DEVELOPMENT REVIEW BOARD--SPEED MEMO

DRB CASE NO/PROJECT NO: 1007033

REF: PROJECT #1007033 / LOT 5-A, BLOCK 7, MESA PARK ADDITION
AGENDA # 11

DRB CASE NO: 1007033

Drawing file: 1007033_Plans / 1007033_MESA PARK ADDITION PLAT OF LOT 5A BLOCK 7 SEC 25 T 10N R3E_PLANS_No_.pdf

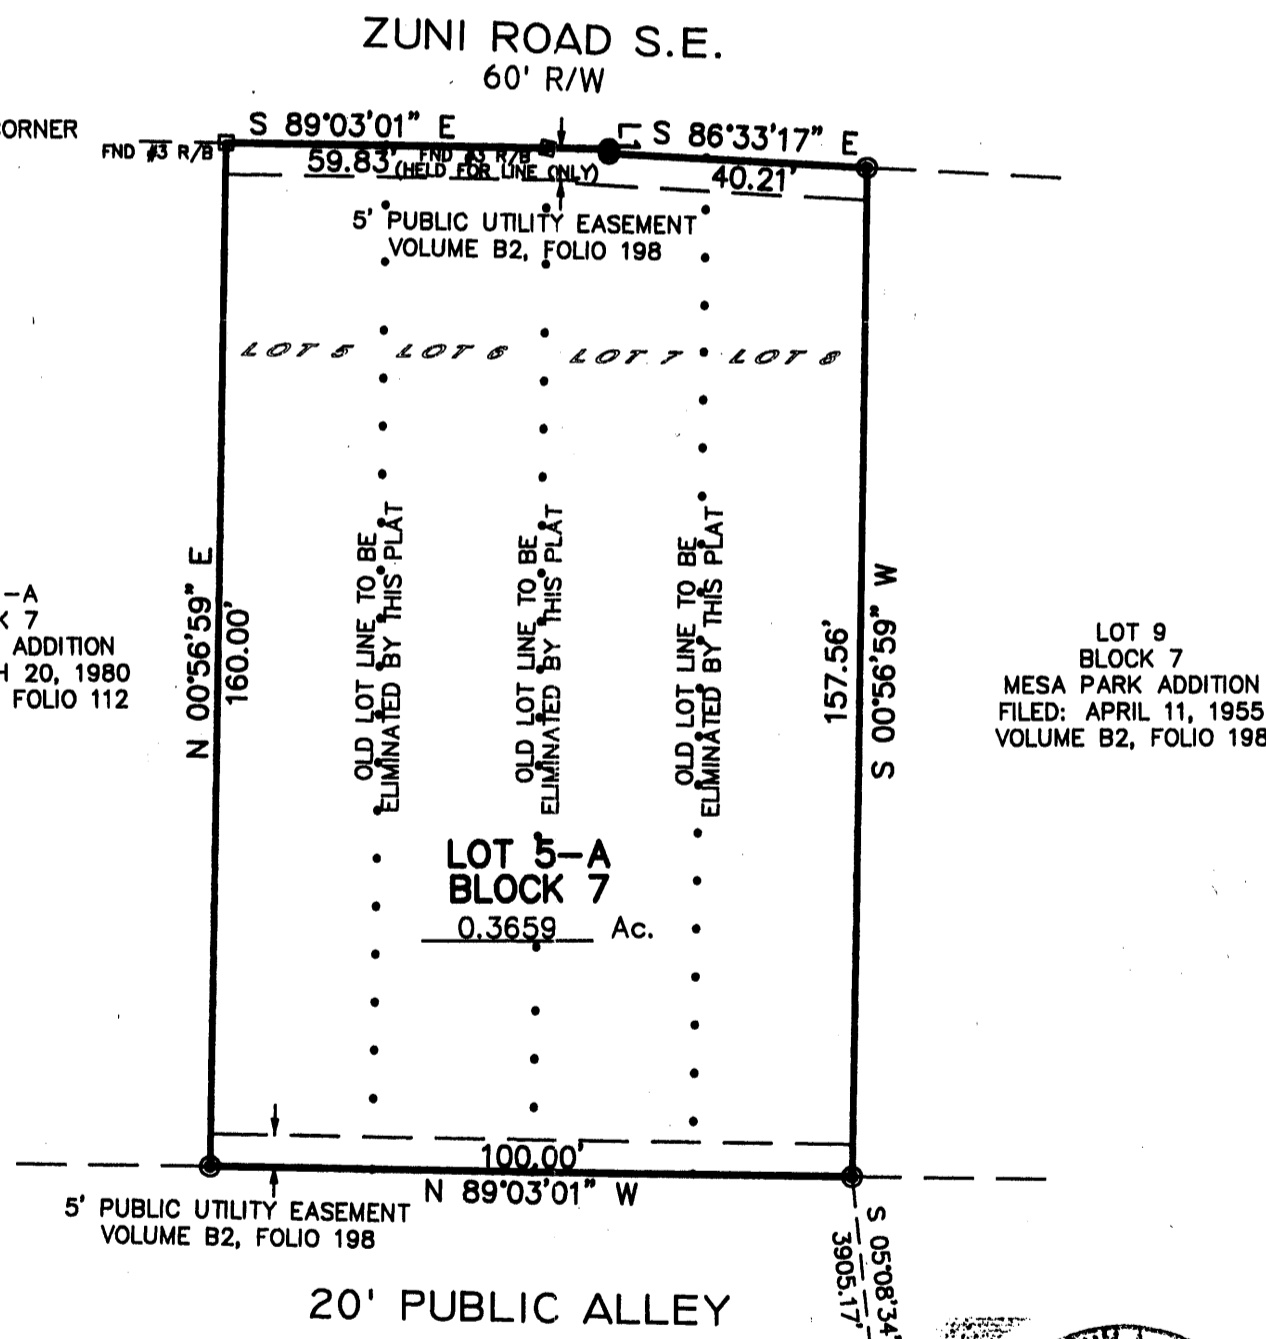
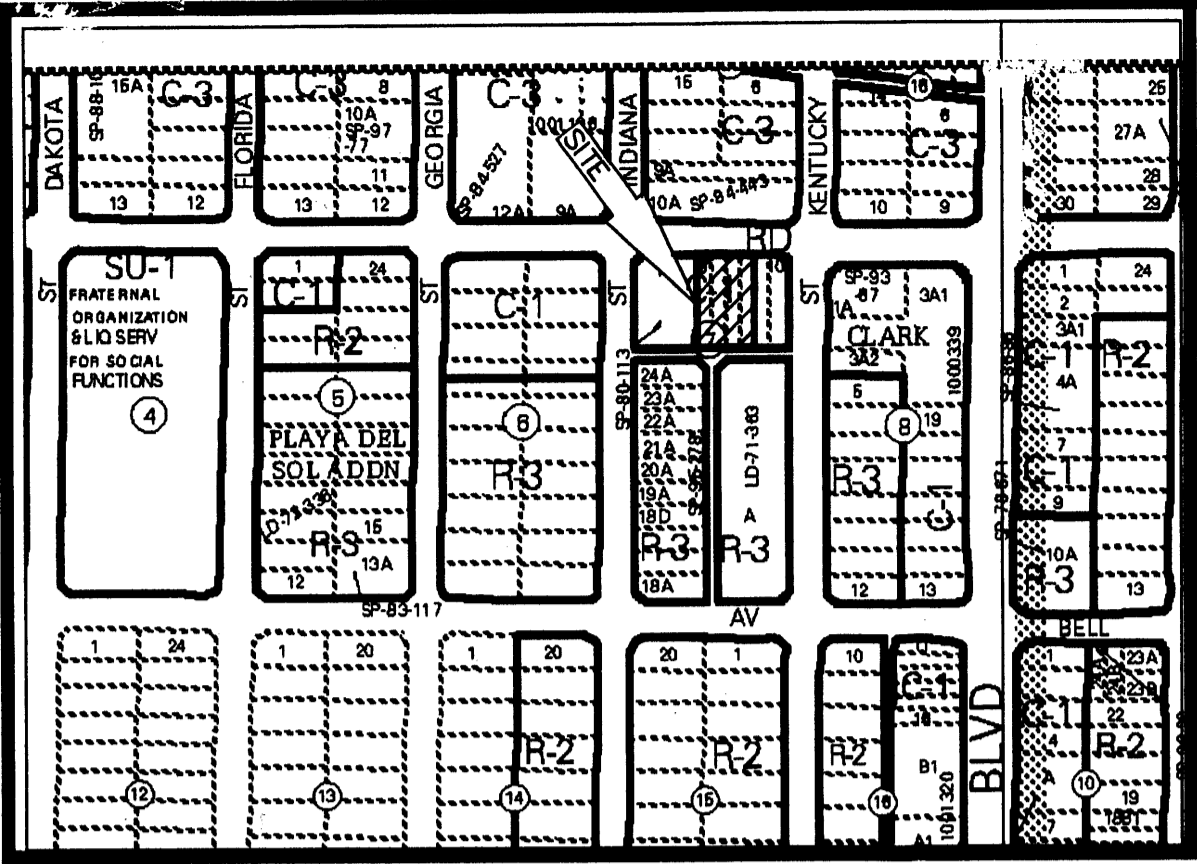
Zuni is a principal arterial. Per the Long Range Roadway System guidelines, a right of way of 80 feet is required. Therefore, a 10-foot right of way dedication is required.
Define the status of the alley. Is it paved? Infrastructure may be required.
